# Screening for Environmental Impact Assessment

**Section 146B Alteration Request (ABP PA92.319013)**

## **Medite DAC Europe**

Redmondstown, Clonmel, County Tipperary

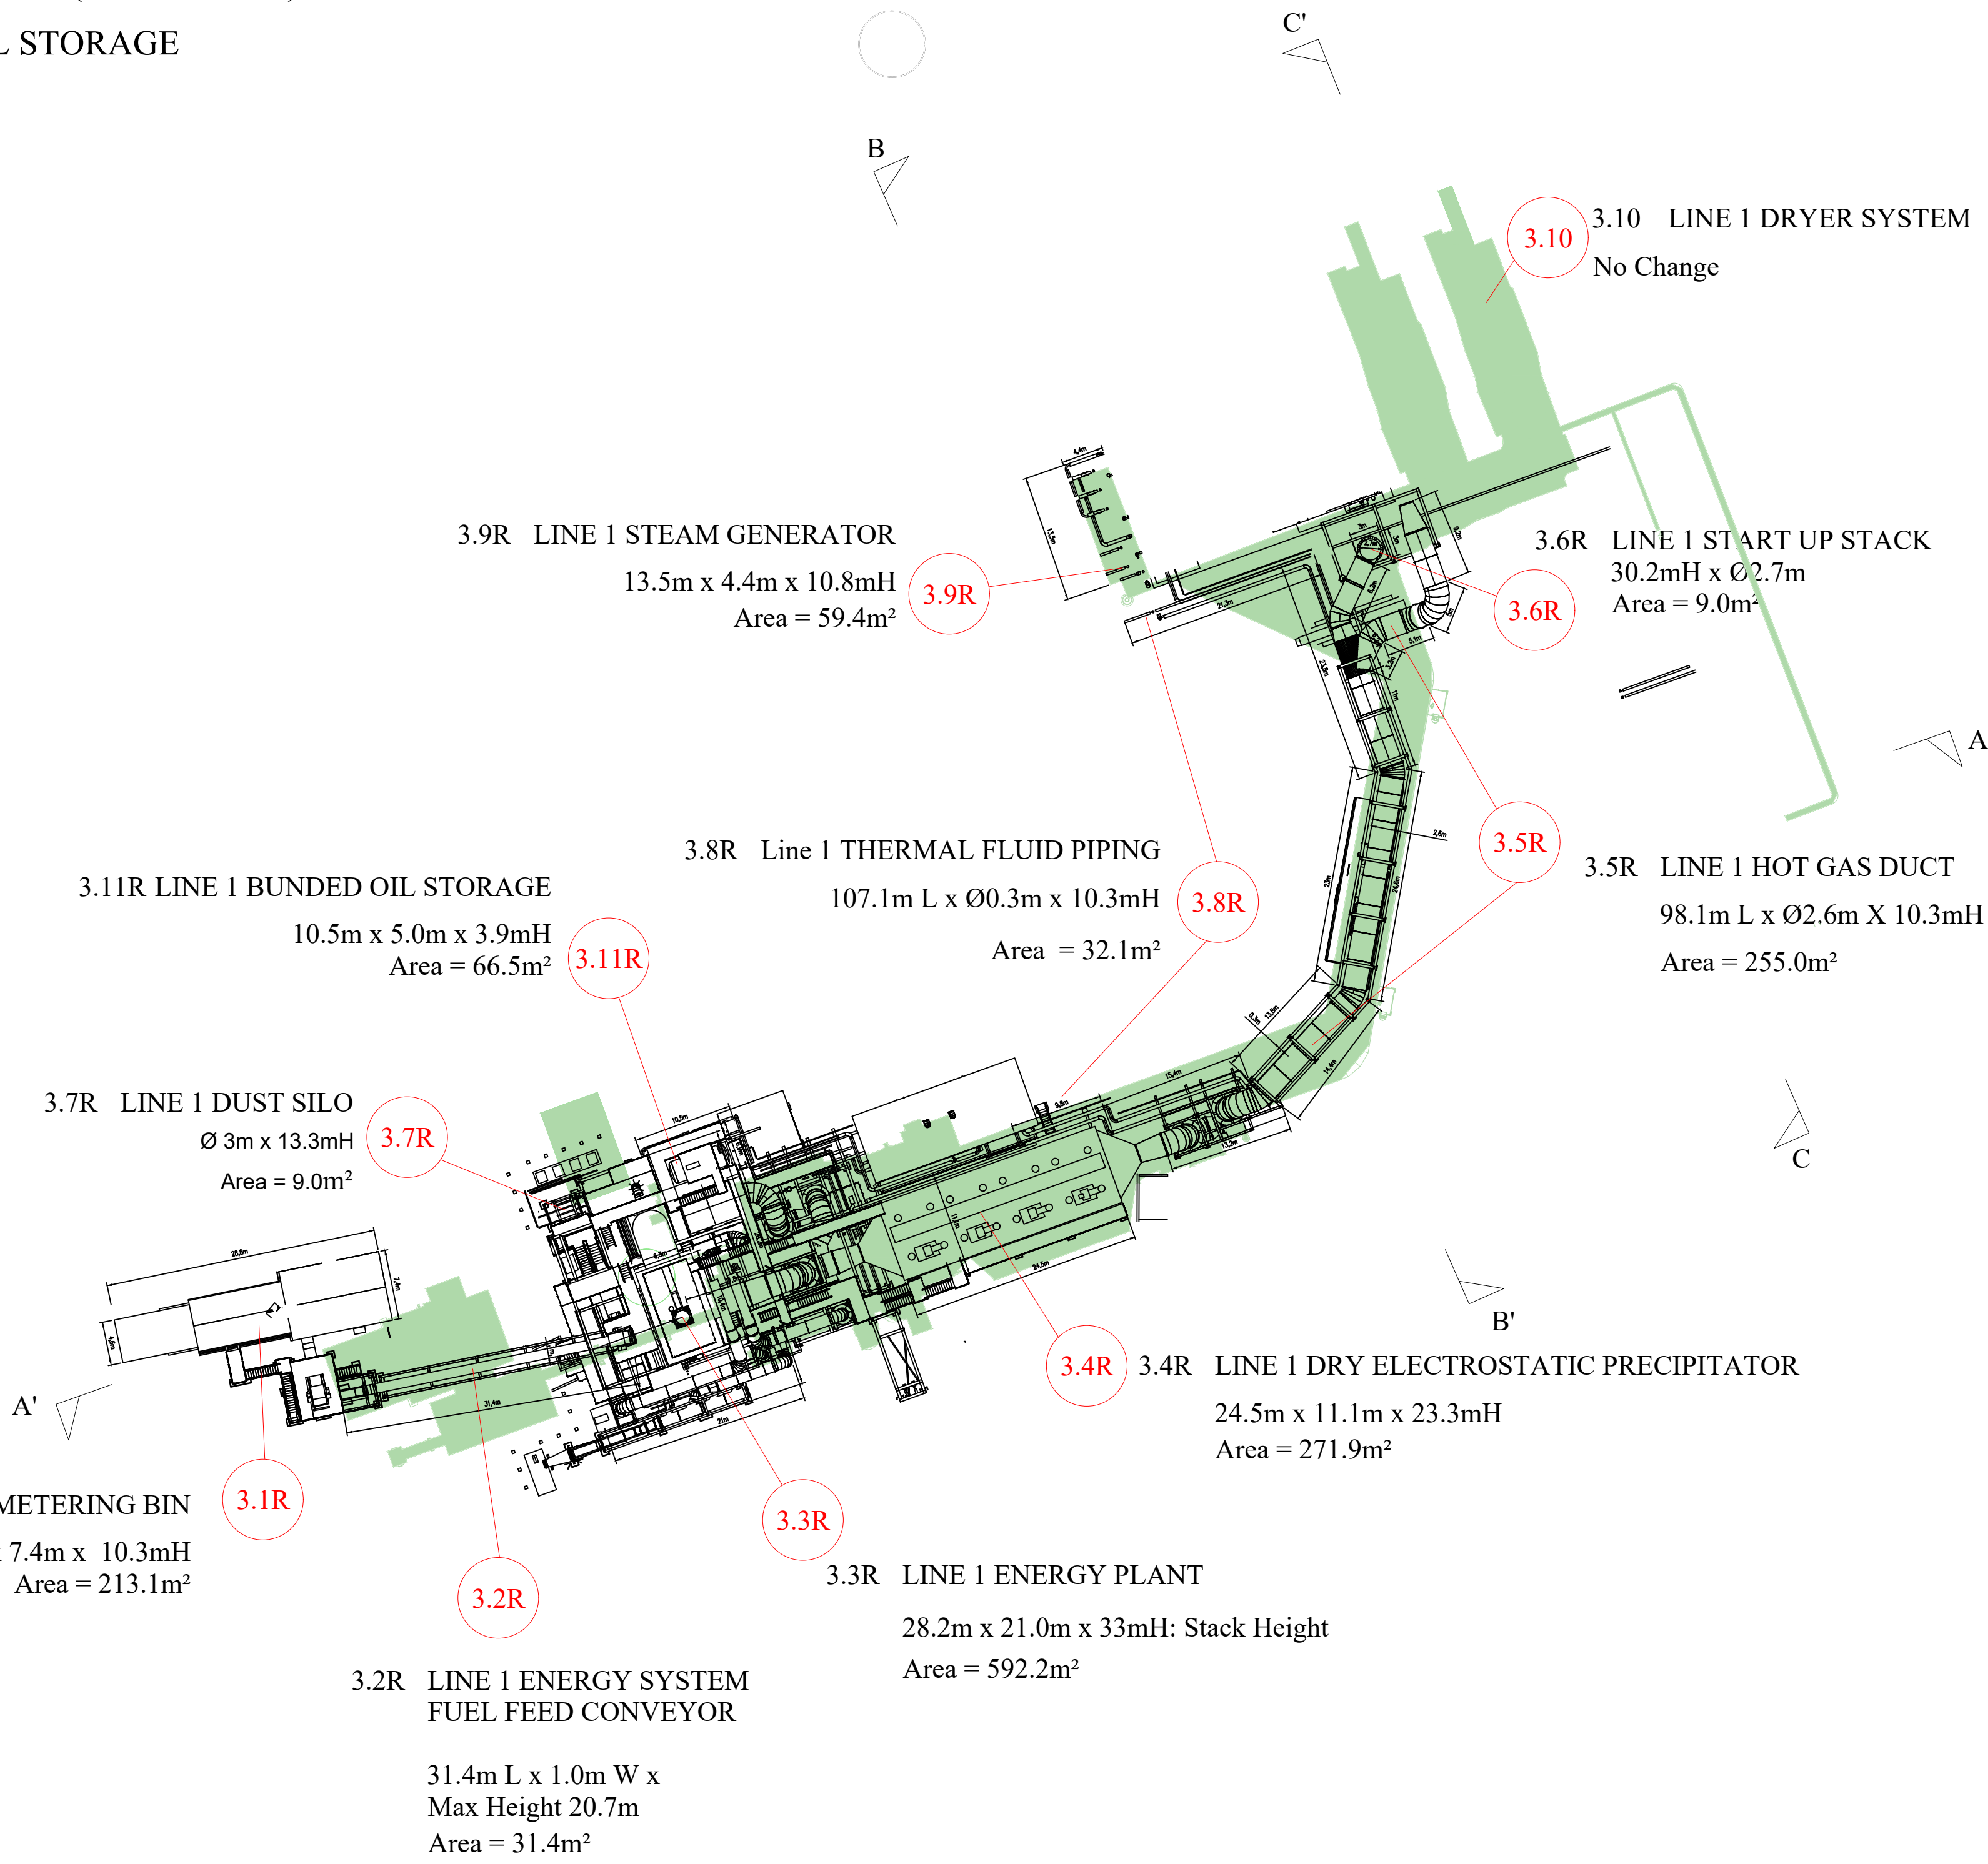
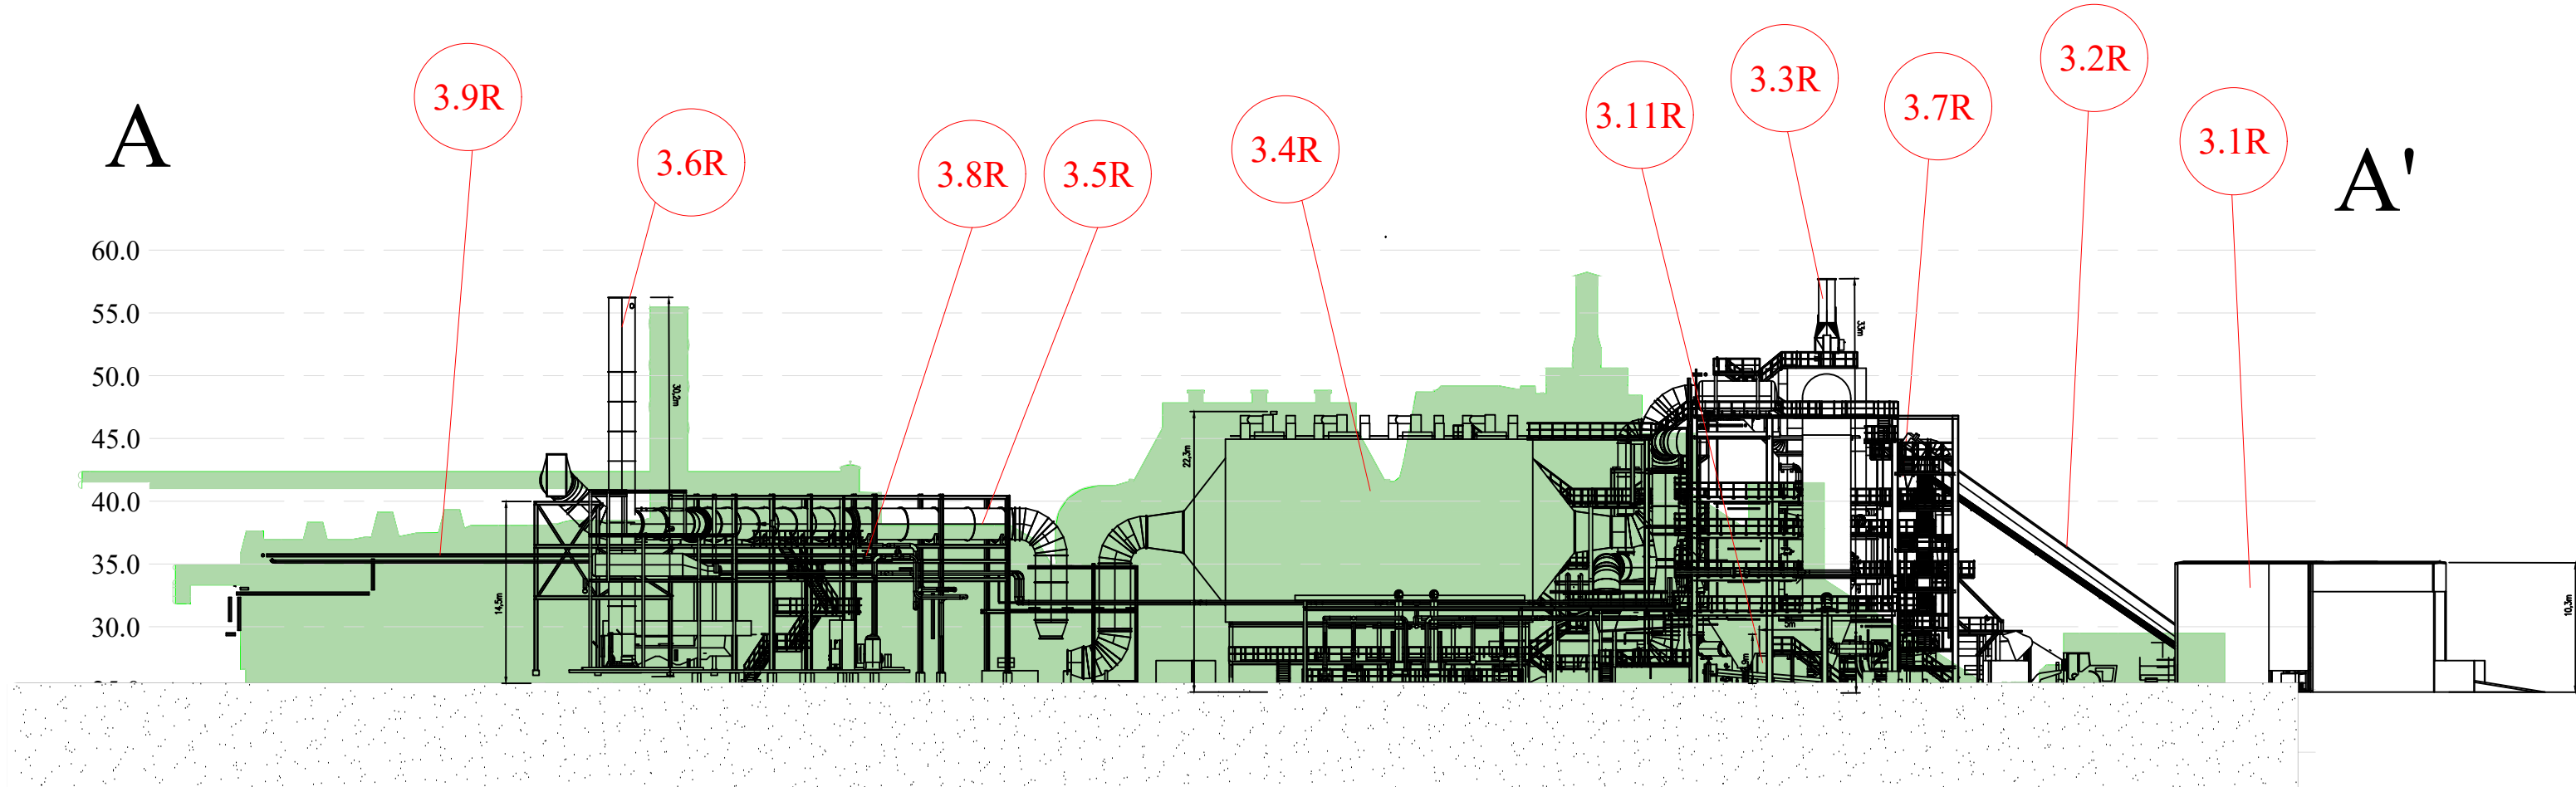
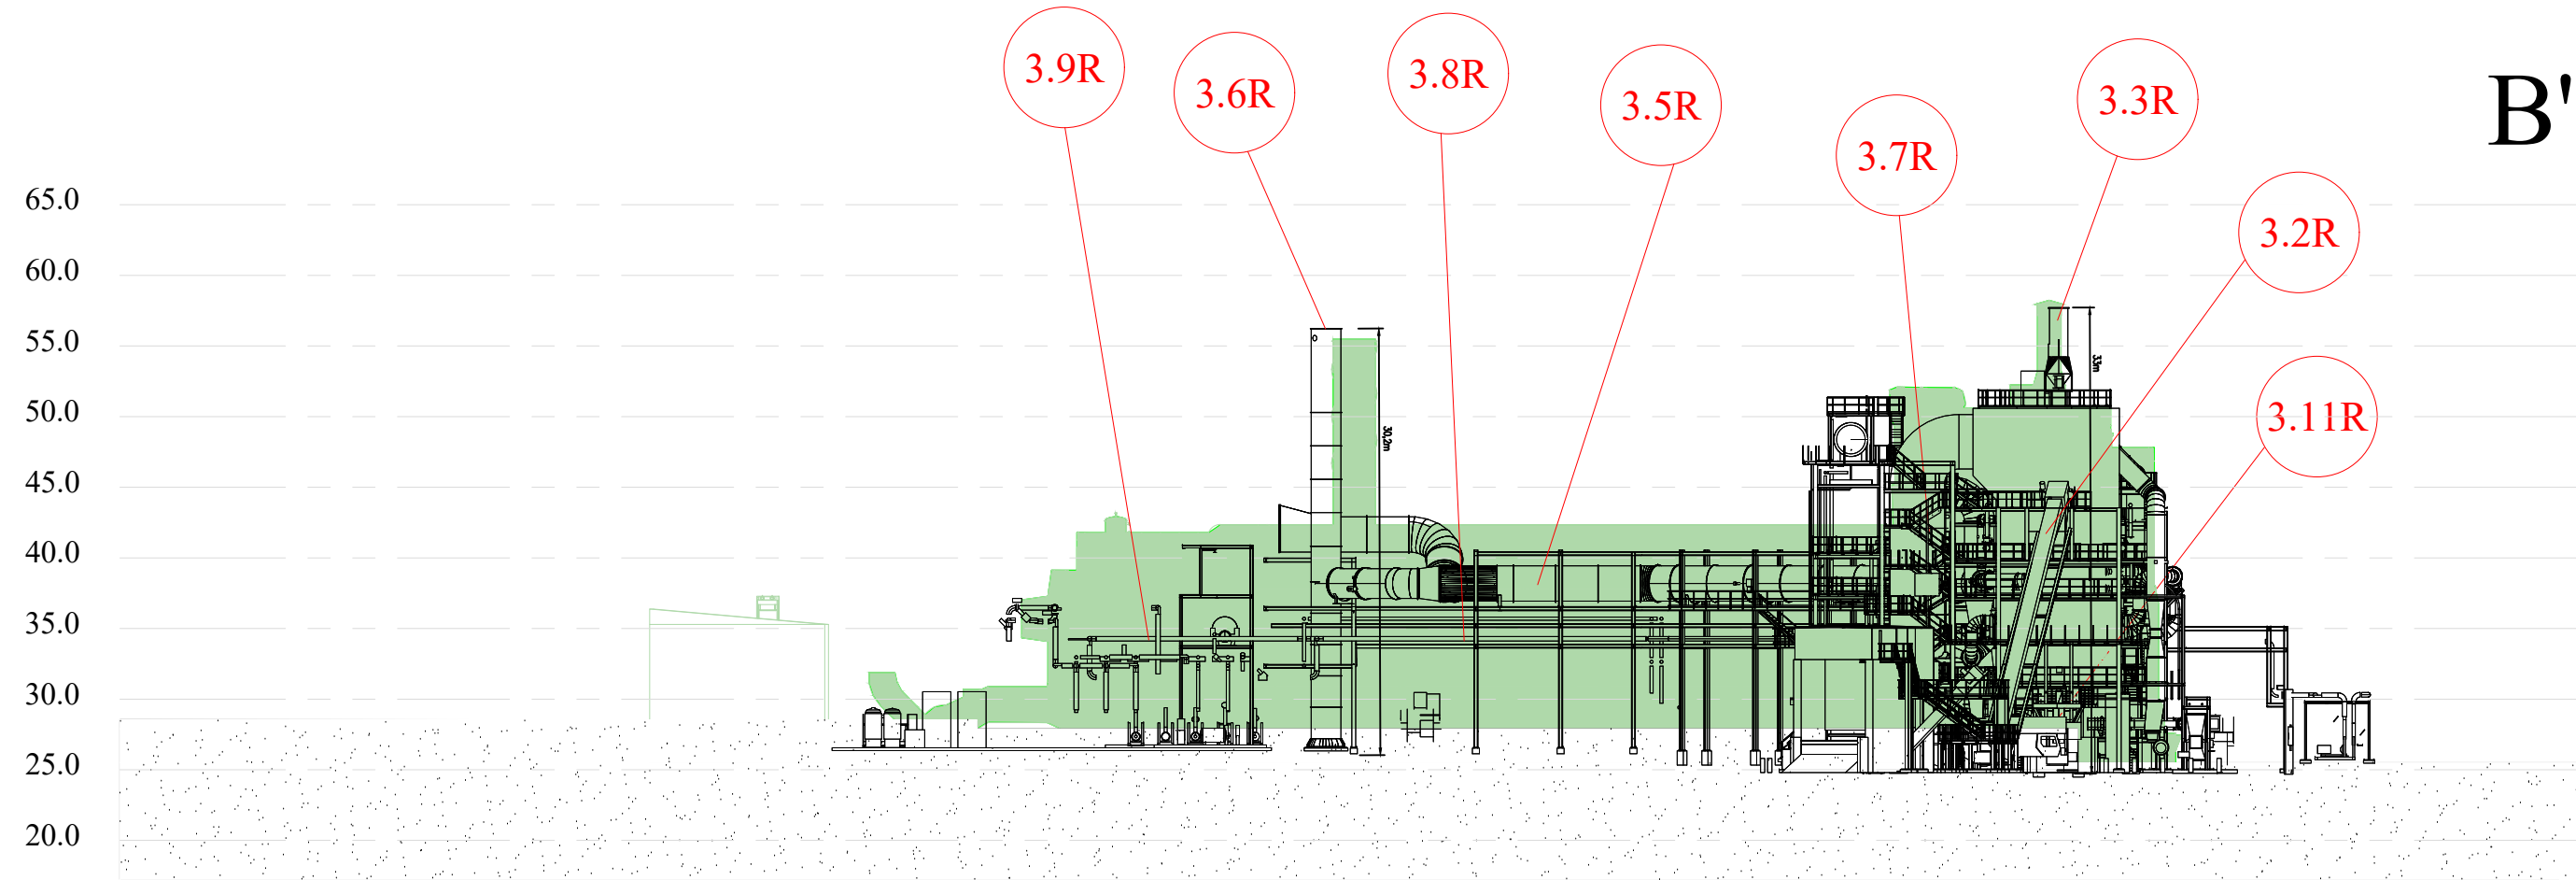
No.	Permitted Item	Description	No. (R)	Proposed Alteration Dimensions	Summary of Alterations
ITEM 3.1	Line 1 Wet Fuel Metering Bin (18.6m x 15.7m x 4.5mH) Area = <del>254.5</del> <sup>5</sup> 292.0m <sup>2</sup>	The wet fuel (bark or chips) is received by the Wet Fuel Metering Bin from the conveying systems referred to in Development Area 1.	ITEM 3.1R	Line 1 Wet Fuel Metering Bin 28.8m 7.4m x 10.3mH  Difference in dimensions: +10.2m x -8.3m x +5.8m H	<b>Proposed Area:</b> 213.1m <sup>2</sup>  <b>Area difference:</b> a reduction of -78.9m <sup>2</sup>  Resized & relocated to match operational requirements

ITEM 3.2	Line 1 Energy System Fuel Feed Conveyor (33.2m L x 1.1m W conveyor Max Height 17.8m Area = 38.0m <sup>2</sup>	The Wet Fuel will be discharged from the Wet Fuel Metering Bin to a Line 1 Wet Fuel Metering Bin Outfeed Weight Belt and a Line 1 Energy System Fuel Feed Conveyor to the Grate Furnace Combustion Chamber with the energy plant.	ITEM 3.2R	Line 1 Energy System Fuel Feed Conveyor 31.4m L x 1.0m W conveyor Max Height 20.7m Difference in dimensions: -1.8m L x -0.1m x +2.9m H	<b>Proposed Area:</b> 31.4m <sup>2</sup>  <b>Area difference:</b> a slight reduction of -6.6m <sup>2</sup>  Adjusted to accommodate metering bin and energy plant  <b>Height increase:</b> +5.8m giving a total height of 10.3m.

No.	Permitted Item	Description	No. (R)	Proposed Alteration Dimensions	Summary of Alterations
	32.5m x 21.6m x 33m Area = <del>442m<sup>2</sup></del> <sup>6</sup> 702m <sup>2</sup>	Inside the TFH, the Wet Fuel will combust together with fresh air provided by the Primary Fan and Secondary Fan inside the Combustion Chamber to produce hot flue gas. An emergency stack on the TFH with a damper will automatically open upon upset conditions. The hot flue gas will supply heat to a thermal fluid that is piped through the energy plant, which in turn provides heat to the Line 1 press and a Steam Generator).		28.2m x 21.0m x 33mH: Stack Height  Difference in dimensions: -4.3m x -0.6m x 0mH	<b>Area difference:</b> a reduction of -109.8m <sup>2</sup>  Reduced size & minor re-location moved by 11.8m west to accommodate equipment

ITEM 3.4	Line 1 Dry Electrostatic Precipitator (within the TFH dims of 27.6m x 13.7m x 23.3mH ) Area = 286.9 m <sup>2</sup>	The Fly Ash inside the Hot Gas will be cleaned and captured by a Dry Electrostatic Precipitator (Dry ESP) and discharged through the SSC Rotary Airlock onto the Wet Ash Conveyor. The Bottom Ash will be discharged through the holes on the grate and recovered by the Wet Ash Conveyor to the Ash Storage Bunker for disposal.	ITEM 3.4R	Line 1 Dry Electrostatic Precipitator (within the TFH dims of 24.5m x 11.1m x 23.3.0mH  Difference in dimensions: -3.1m x -2.6m x 0mH	<b>Proposed Area:</b> 271.9m <sup>2</sup> <b>Area difference:</b> a slight reduction of -15.0m <sup>2</sup>  Resized & Location moved to accommodate equipment

ITEM 3.5	Line 1 Hot Gas Duct 105m long x Ø3.2m Area = 336.0m <sup>2</sup>	The Hot Gas will be transported to the Line 1 Dryer Systems (Core and Face dryers) via the Hot Gas Duct where it will be mixed with ambient air for the purpose of drying the wet wood fibre. The existing mixing chambers located within the Line 1 Dryer Building will be modified to accommodate the new hot gas duct.	ITEM 3.5R	Line 1 Hot Gas Duct 98.1m long x Ø2.6m Difference in dimensions: -6.9m x Ø-0.6m	<b>Proposed Area:</b> 255.0m <sup>2</sup> <b>Area difference:</b> a reduction of -81.0m <sup>2</sup>

ITEM 3.6	Line 1 Start Up Stack (30.2mH x Ø3.6m)	The Hot Gas duct will contain an abort gate & Start-up Stack. This Abort Gate and start-up stack serves as a by-pass of the Hot Gas Flow	ITEM 3.6R	Line 1 Start Up Stack 30.2mH x Ø2.7m	<b>Proposed Area:</b> 9.0m <sup>2</sup>

No.	Permitted Item	Description	No. (R)	Proposed Alteration Dimensions	Summary of Alterations
	Area = 10.8m <sup>2</sup>	to the dryer to atmosphere in case the dryer system is in upset conditions or during plant start-up.		Difference in dimensions: 0mH x -0.9m	<b>Area difference:</b> a slight reduction of -1.8m <sup>2</sup> Moved due to constructability constraints 30.2 m height is maintained and relocated by 10.3m east.

ITEM 3.7	Line 1 Sander Dust Silo (Ø 6.0m x 16mH) Area = 28.3m <sup>2</sup>	As referenced in 'Pneumatic (Dry Fuel) Systems' in Development Area 1, the existing extraction systems are to be modified and will a proposed Sander Dust Silo Ø 6.0m x 16mH and associated filter plant, located adjacent to the proposed Line 1 Energy Plant. The Sander Dust Silo will discharge material into the Line 1 Energy Plant as fuel.	ITEM 3.7R	Line 1 Sander Dust Silo (Ø 3.0m x 13.3mH) Difference in dimensions: 0m	Proposed Area: 9.0m <sup>2</sup> <b>Area difference:</b> reduction of -19.3m <sup>2</sup> Incorporated into the frame structure of the to energy plant

ITEM 3.8	Line 1 Thermal Fluid Piping 217m L x Ø 0.6m x 16.3mH Area = <del>40.9</del> 130.2 m <sup>2</sup>	The Thermal Fluid Piping will transport the heated thermal fluid to and from the energy plant and both the existing Line 1 Press and a new steam generator.	ITEM 3.8R	Line 1 Thermal Fluid Piping 107.1m L x Ø 0.3m x 10.3mH Difference in dimensions: -109.9m x Ø-0.3m	<b>Proposed Area:</b> 32.1 m <sup>2</sup> <b>Area difference:</b> a reduction of -98.1 m <sup>2</sup>

ITEM 3.9	Line 1 Steam Generator 14.4m x 3.5m x 17.9mH Area = 47.5m <sup>2</sup>	The Steam generator will use heated thermal fluid to generate steam for the various existing steam users on Line 1. The new steam piping will connect the steam generator to the existing steam pipe infrastructure.	ITEM 3.9R	Line 1 Steam Generator 13.5m x 4.4m x 10.8mH Difference in dimensions: -0.9m x +0.9m x -7.1mH Reduction of external works as re-located inside existing building.	<b>Proposed Area:</b> 59.4m <sup>2</sup> <b>Area difference:</b> an increase of +11.9m <sup>2</sup> Reduction in height of pipe work

No.	Permitted Item	Description	No. (R)	Proposed Alteration Dimensions	Summary of Alterations
ITEM 3.10	Line 1 Dryer System 34.0m x 17.5m x 13.9mH Area = 505.7m <sup>2</sup>	The Hot Gas generated by the new Line 1 Energy plant will be utilised in the dryer system to dry wood fibre to produce MDF.	ITEM 3.10	Line 1 Dryer System 34.0m x 17.5m x 13.9mH Area = 505.7m <sup>2</sup> As permitted; Inside existing building	No Area Difference
ITEM 3.11	Line 1 Bunded Oil Storage 10.4m x 6.4m x 3.1mH Area = 66.5m <sup>2</sup>	Bunded Oil Storage Tank	ITEM 3.11R	Line 1 Bunded Oil Storage 10.5m x 6.9m x 3.9mH Difference in dimensions: +0.1m x +0.5m x +0.8mH	<b>Proposed Area:</b> 72.5m <sup>2</sup> <b>Area difference:</b> an increase of +6.0m <sup>2</sup>
